Date: 27<sup>th</sup> October 2022  
Our Ref: P1320-2-0010

**Re: Hydrological & Hydrogeological Responses to An Bord Pleanála Further Information Request and Third-Party Submission in relation to the proposed Coole Wind Farm, Co. Westmeath (ABP Ref: 309770-21)**

Hydro-Environmental Services (HES) were requested by MKO Ireland (MKO) to respond to a further information request from An Bord Pleanála (ABP) with respect to geological, hydrological, and hydrogeological matters raised in relation to the proposed Coole Wind Farm SID application, Co. Westmeath.

Date: 17/02/2021 Checked By: MG

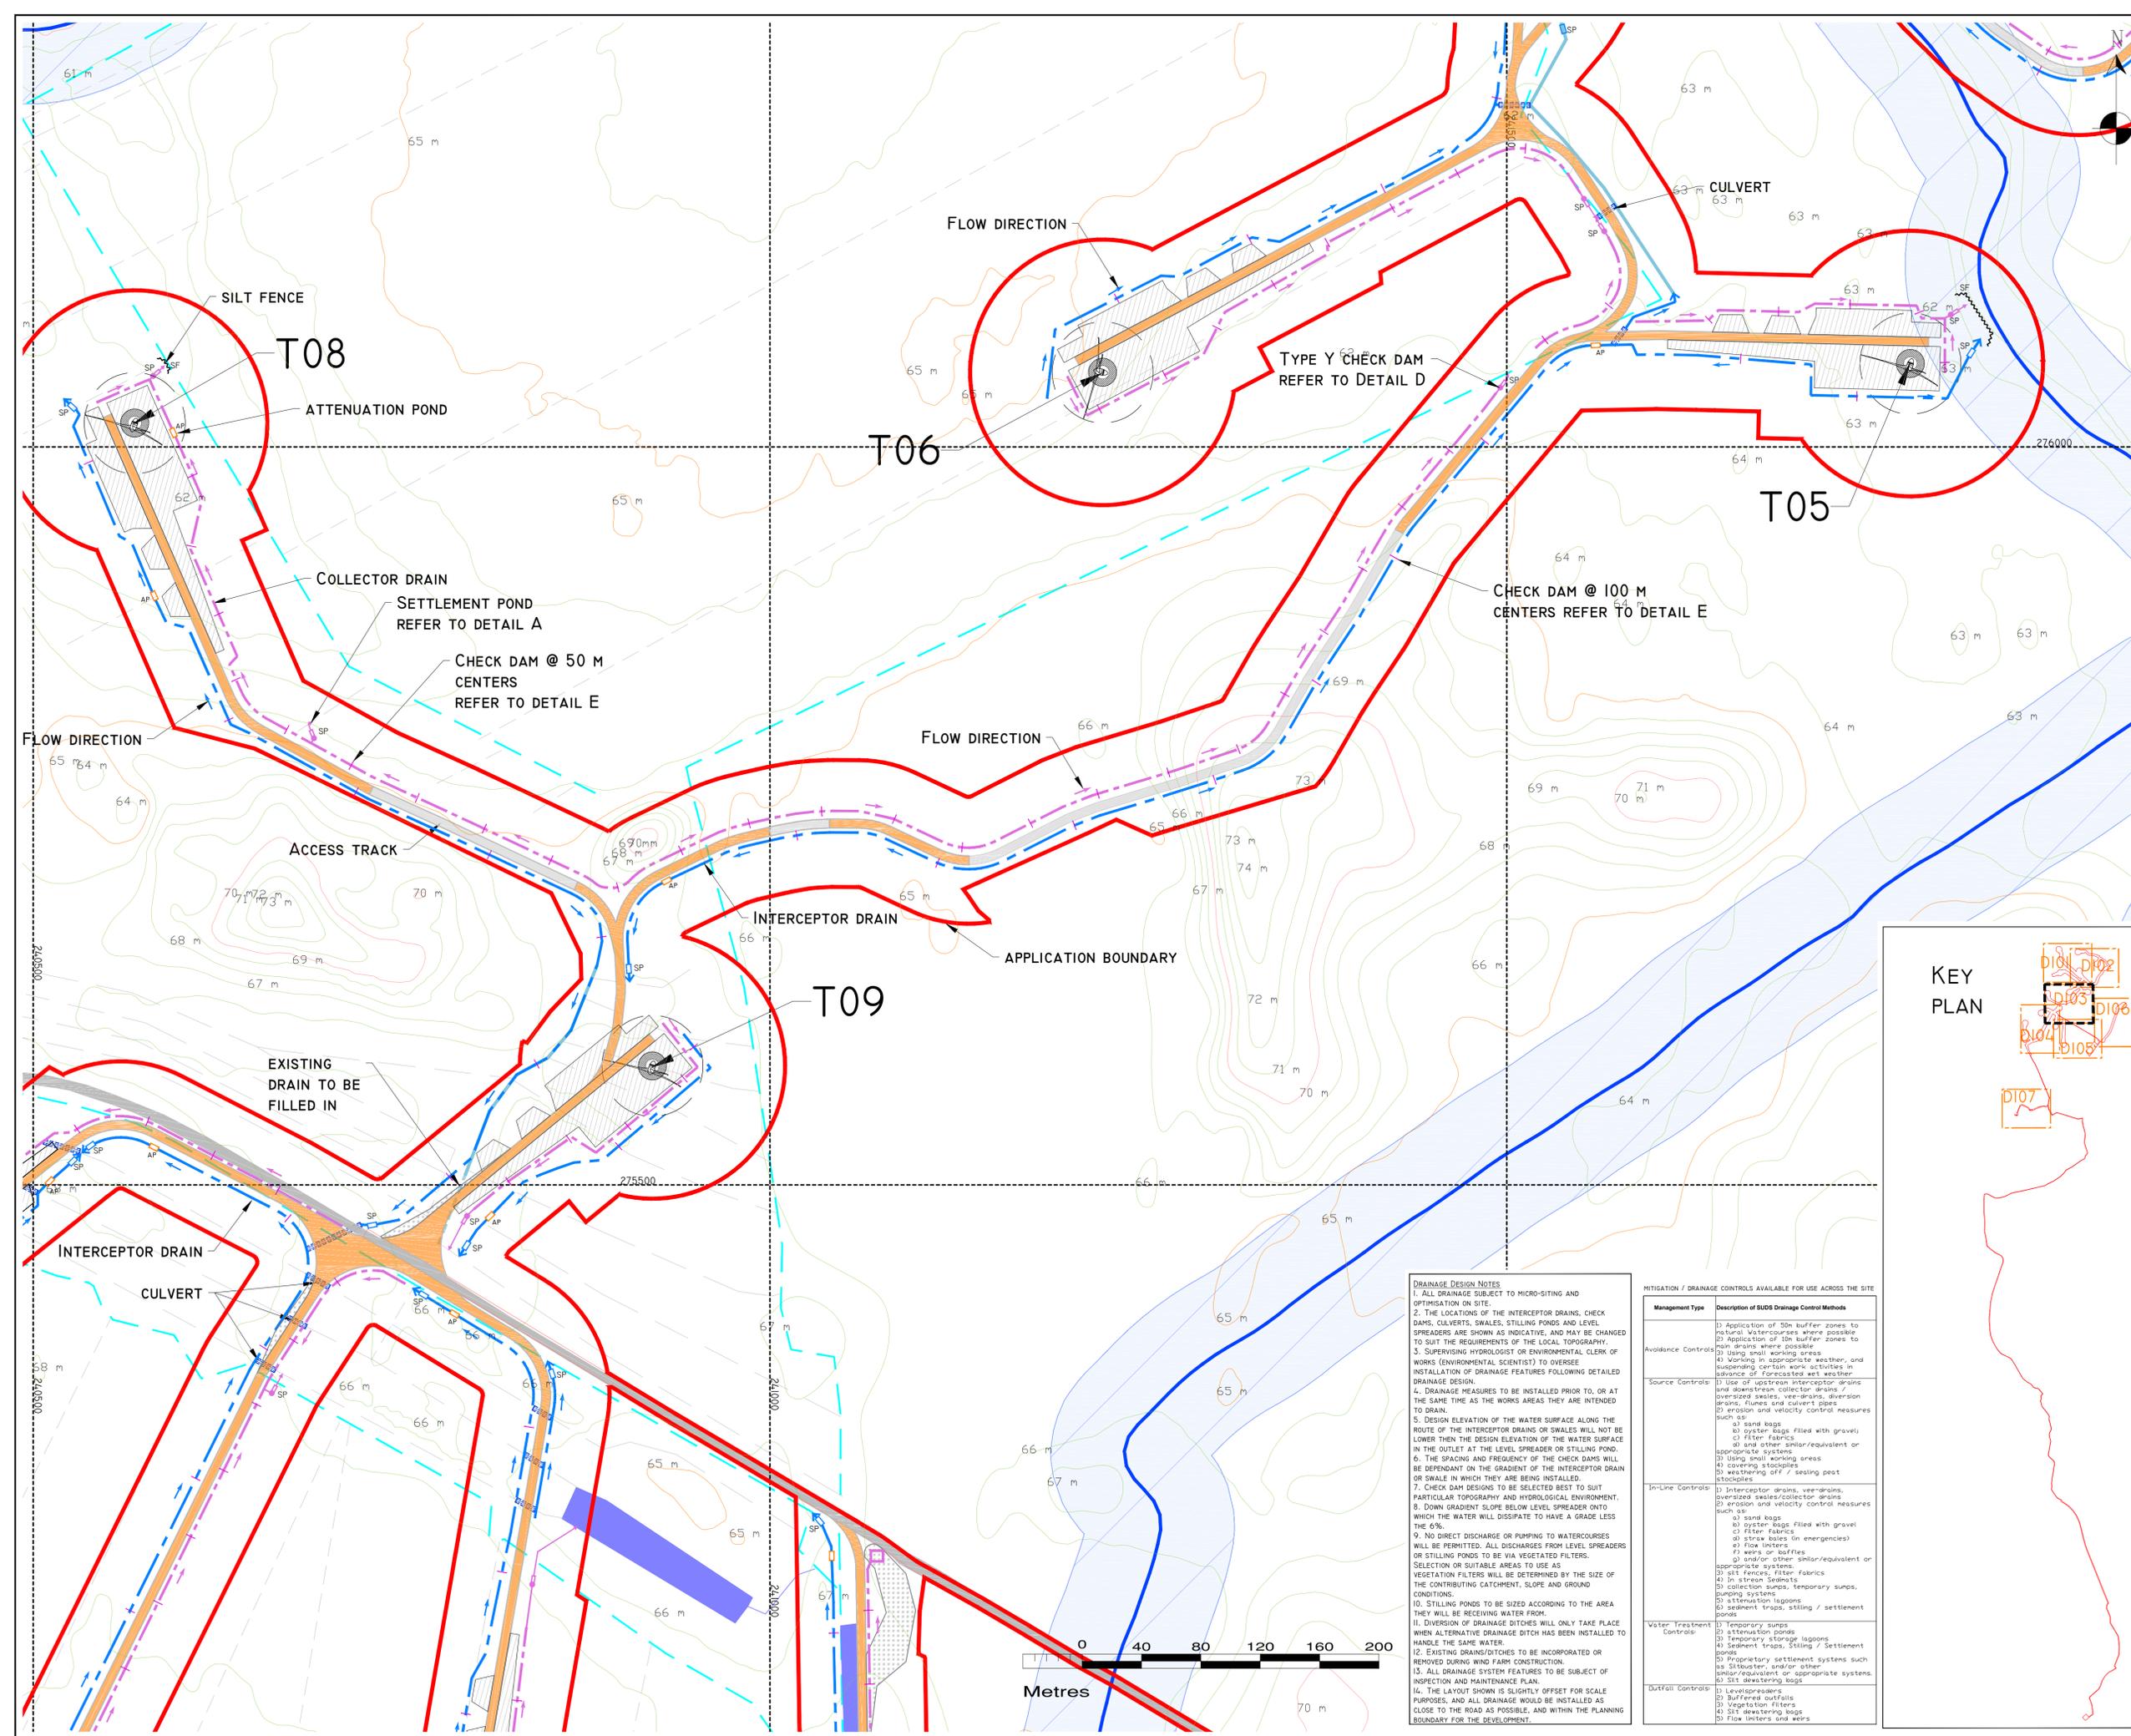
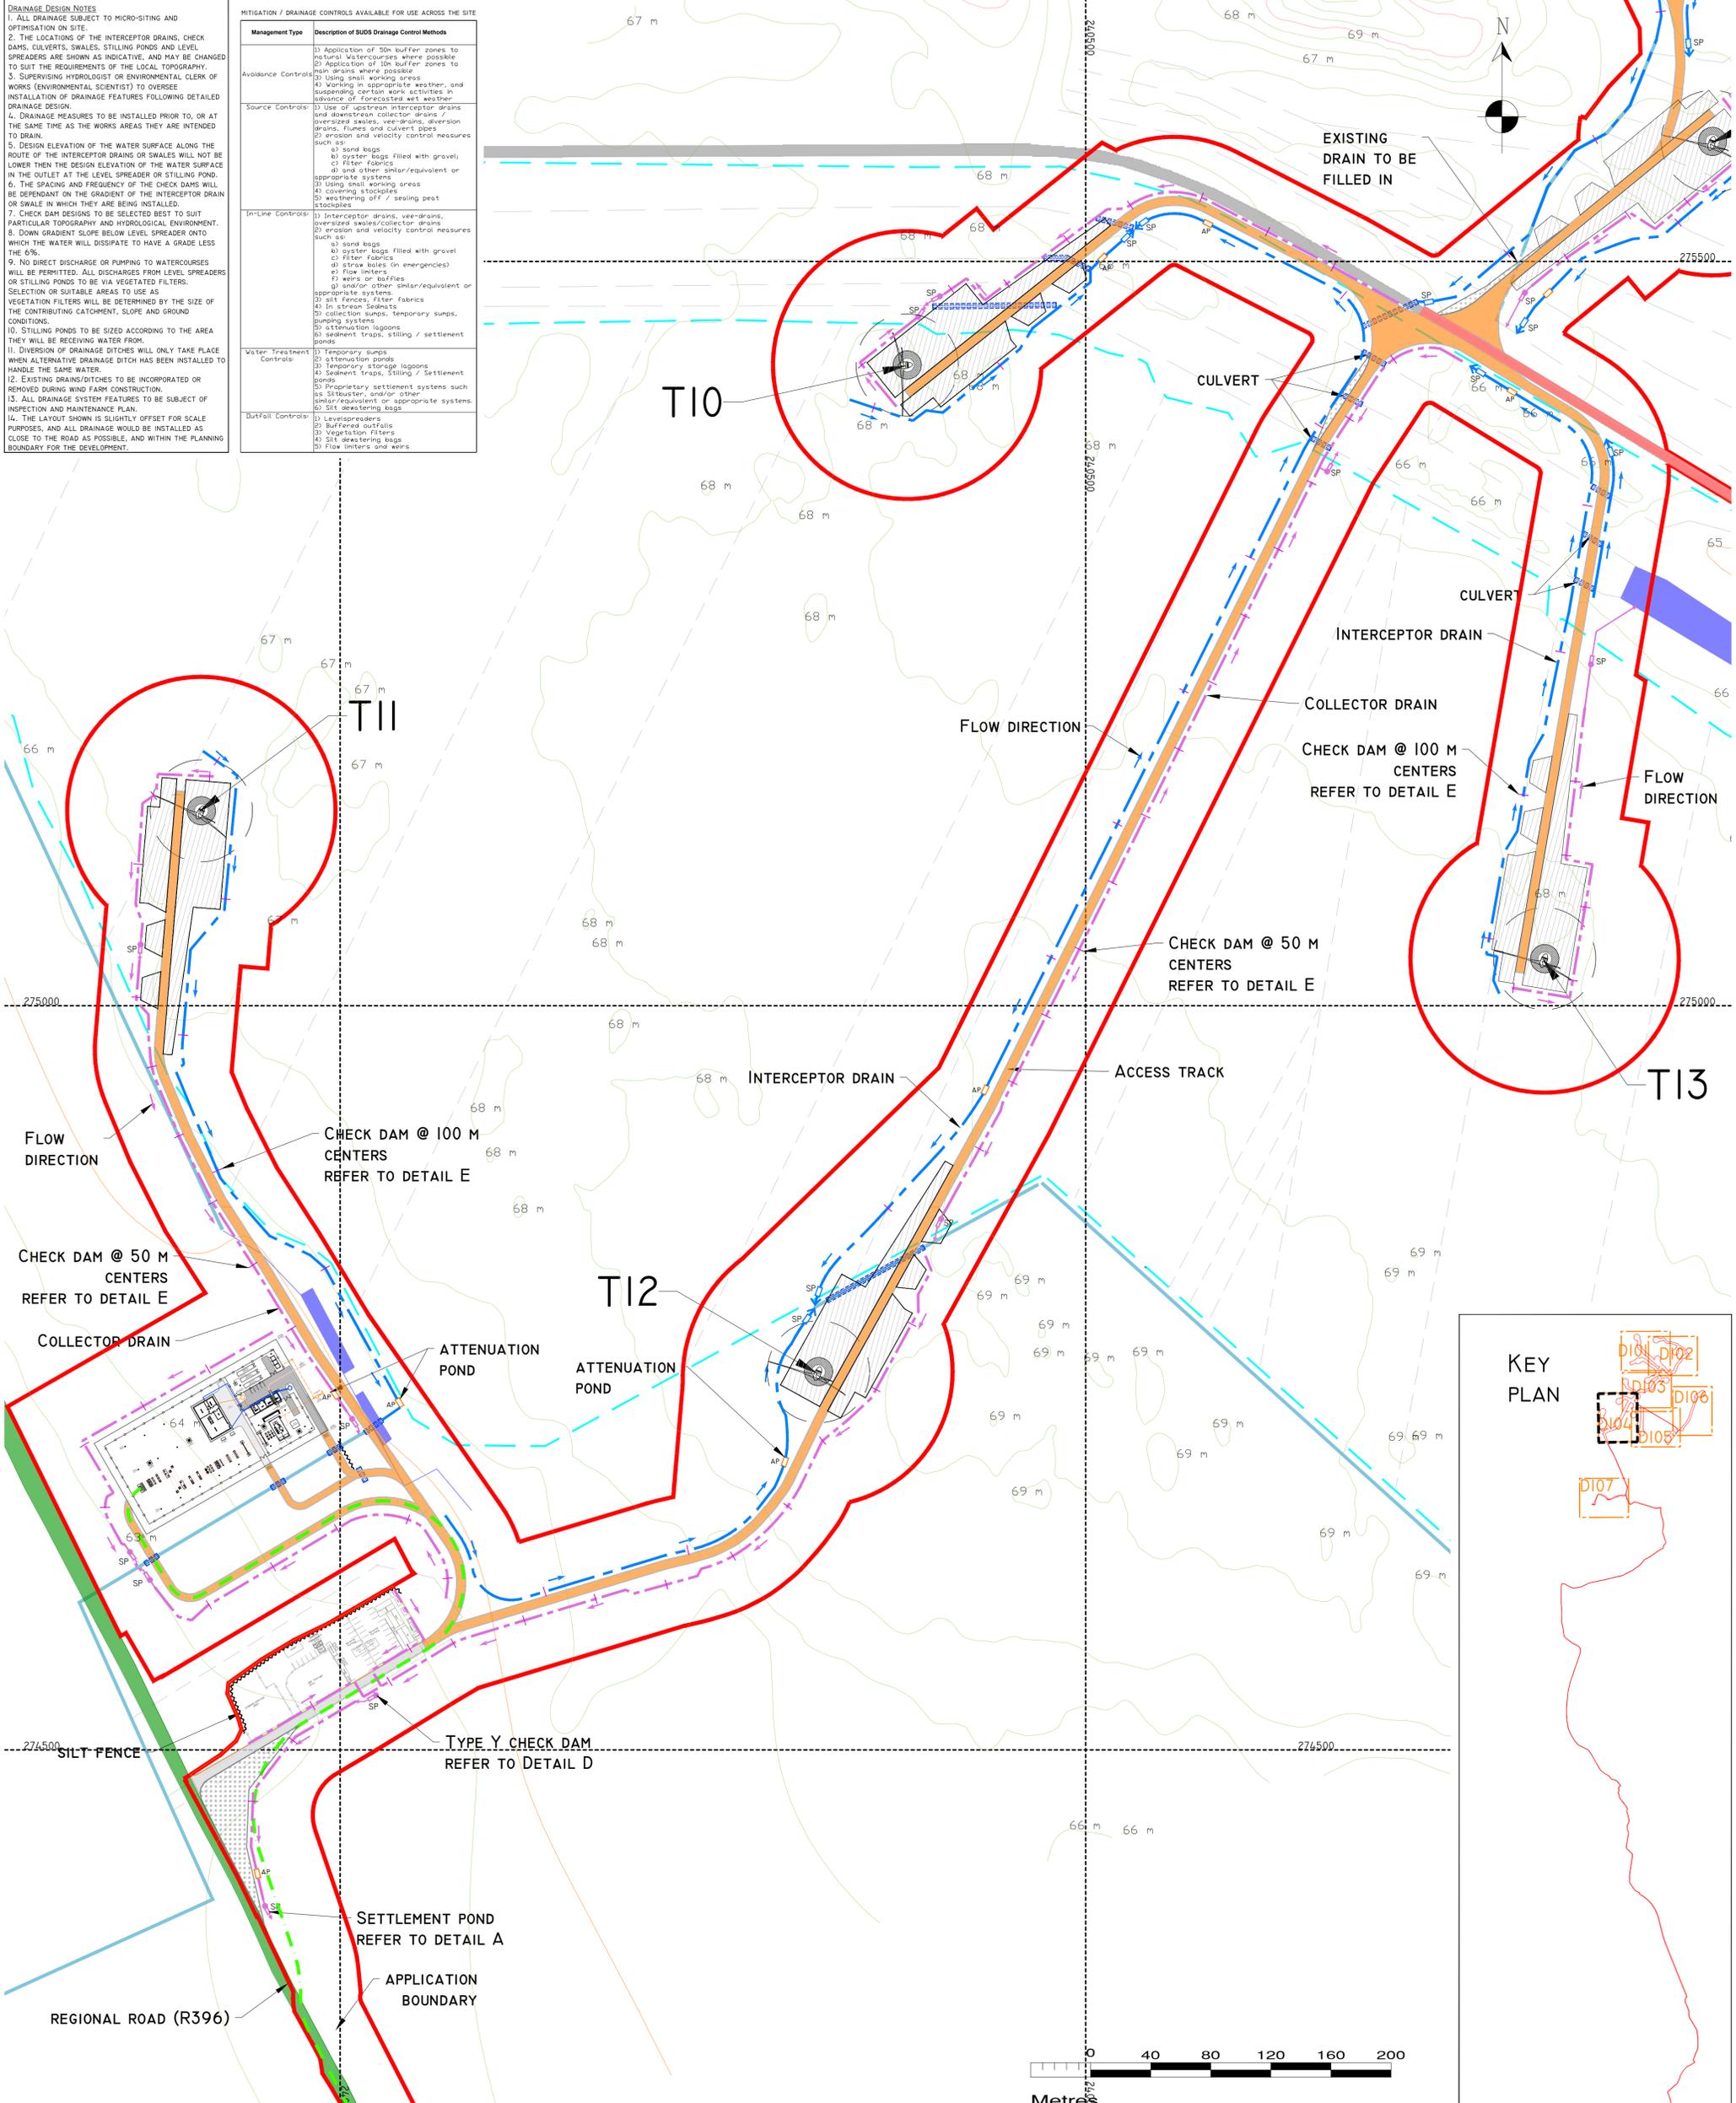
- b) The potential for impacts on Gariskil Bog and Scragh Bog as a result of the effects of drainage works.*
- c) The need to identify the location of all mitigation measures involved in the construction phase drainage management.*

*“You are requested to clarify the layout and management arrangements for the operational drainage structure.”*

The locations of proposed mitigation measures to be implemented within the Coole Wind Farm site during the construction phase including check dams, attenuation ponds, settlement ponds, silt fences, and collector and interceptor drains are shown in Drawings D101 to D107 (EIAR Appendix 4.9).

The drainage system as outlined in drawings D101-D107 (Refer to Appendix 4-9 and 9-3 of the EIAR) will be utilised and maintained during the operational phase of the proposed Wind Farm. The maintenance and management of the drainage system will be included within the overall maintenance regime of the Wind Farm.

- The inspection and maintenance of swales and settlement ponds;
- Inspecting cross-drains for any blockages, and removal of any blockages identified;
- Inspecting and maintaining outfalls to existing field drains;
- Inspecting the existing roadside drains for any obstructions, and removal of any obstructions identified;
- Inspecting the progress of the re-establishment of vegetation and where required testing the water quality at the outfalls periodically; and,
- Inspection and regular cleaning of drainage channels and settlement ponds. Drainage inspections and maintenance will be in completed accordance with CIRIA C697 SuDS and Maintenance Manual.
